Fosse Green Energy

EN010154

8.15 Statement of Common Ground with
the UK Health and Security Agency

Version	Date	Issue Purpose
Rev 1	24 March 2026	Deadline 3A

Plate 3 The Maximum Expected Exposure to Magnetic Fields

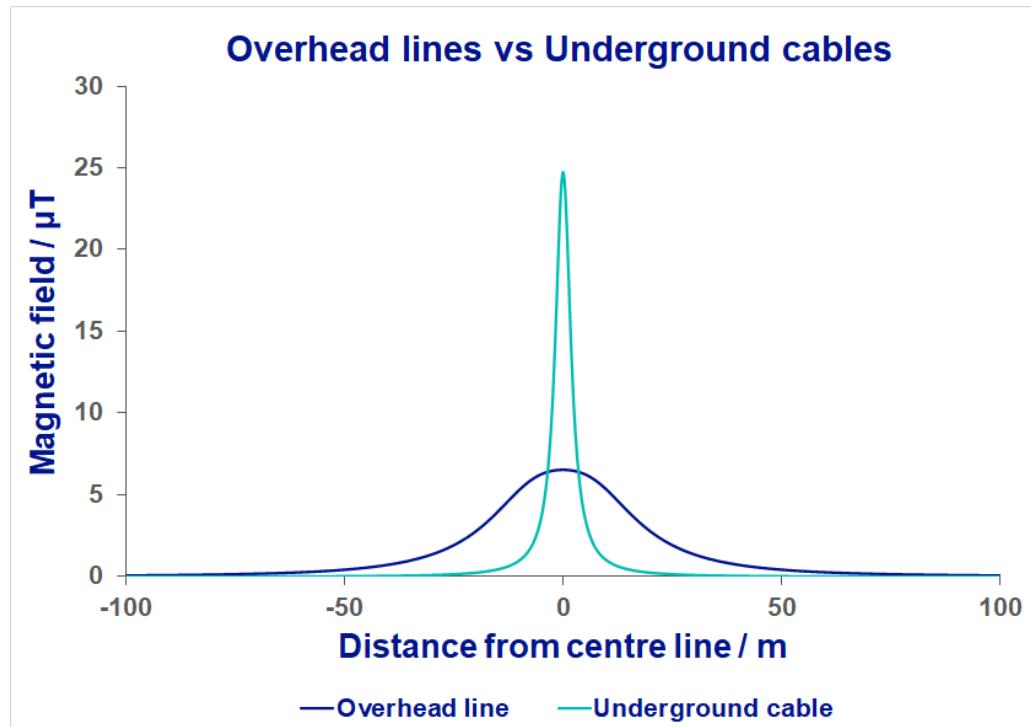
Reference	Description of Matter	UK Health Security Agency Position	Applicant Position	Status
4.2.1	EMF Exposure	The Electromagnetic Field (EMF) exposure estimates quoted in section 14.8 of the ES and Appendix 14-F refer to a graph used to illustrate “the comparison between the magnetic fields of a 400kV underground cable and an equivalent overhead line”, and are not specific to the 400 kV cables in the proposed development (e.g. depth of the cable, current, cable layout) nor it is specified in the reference that the graph provides maximum magnetic field levels for 400 kV overhead lines in general. For potential EMF health impacts, UKHSA advises that according to the following voluntary Code of Practice (details are given in Appendix A to this SoCG), if the cable exceeds 132 kV, a calculation or measurement of the maximum fields directly above the cable is recommended to demonstrate compliance with the 1998 International Commission on Non-Ionizing Radiation Protection (ICNIRP) guidelines.	As stated in Appendix 14-F: Electromagnetic Fields Assessment of the ES [APP-175] exposure Limits in the UK are based upon the 1998 International Commission on Non-Ionizing Radiation Protection (ICNIRP) guidelines (Ref 2), on the advice of the Health Protection Agency (HPA). The ICNIRP ‘reference levels’ for the public are 100µT for magnetic fields and 5,000 volts per metre (or 5kV/m) for electric fields. These are the levels above which more investigation is needed if this level of exposure is likely to occur; the permitted levels of exposure are somewhat higher, 360µT and 9kV/m. They apply where the time of exposure is significant, for instance in a residence. As a worst-case the lower ‘reference level’ of 100µT and 5kV/m was used in assessment as the threshold at which potentially significant effects could occur. The National Grid document ‘Undergrounding high voltage electricity transmission lines’ (2015) (Ref 3) states that for a 400kV cable buried at 0.9 m	Agreed

Reference	Description of Matter	UK Health Security Agency Position	Applicant Position	Status
		<p>The UK Health Security Agency is in agreement with the Applicant's consideration of EMF Exposure.</p>	<p>depth, the typical magnetic field is 24 microteslas when on top of the cable and 3 microteslas at 5m from the centreline, with the maximum level known by National Grid being 96 microteslas on top of the cable at 0.9 m depth, and 13 microteslas at 5m. Taking into account this guidance and the UK limits (Ref 4) set for safety of members of the public, the maximum reported electromagnetic field for the 400kV grid connection cables within the Cable Corridor of the Proposed Development buried at a minimum depth of 0.9m as per Chapter 3: The Proposed Development of the ES [REP1-0168] would comply with the ICNIRP limits and were therefore scoped out of the assessment. Therefore, it is not considered necessary or that any value would be added by carrying out a calculation for the Proposed Development. The desk based secondary information on EMF emissions from 400kV cable circuits is considered sufficient at this stage, which is a concept design stage at which time the precise depth and location of the Cable Corridor is not known and will be determined at detailed design stage, post consent, with the parameters consented</p>

Reference	Description of Matter	UK Health Security Agency Position	Applicant Position	Status
			within the DCO. The secondary data is sufficient to demonstrate there will not be any likely significant effects or exceedances of safe thresholds for members of the public. Any future calculations, should UKHSA require it, would be better provided at detailed design stage, once the precise location and depth of the cable circuits are known.
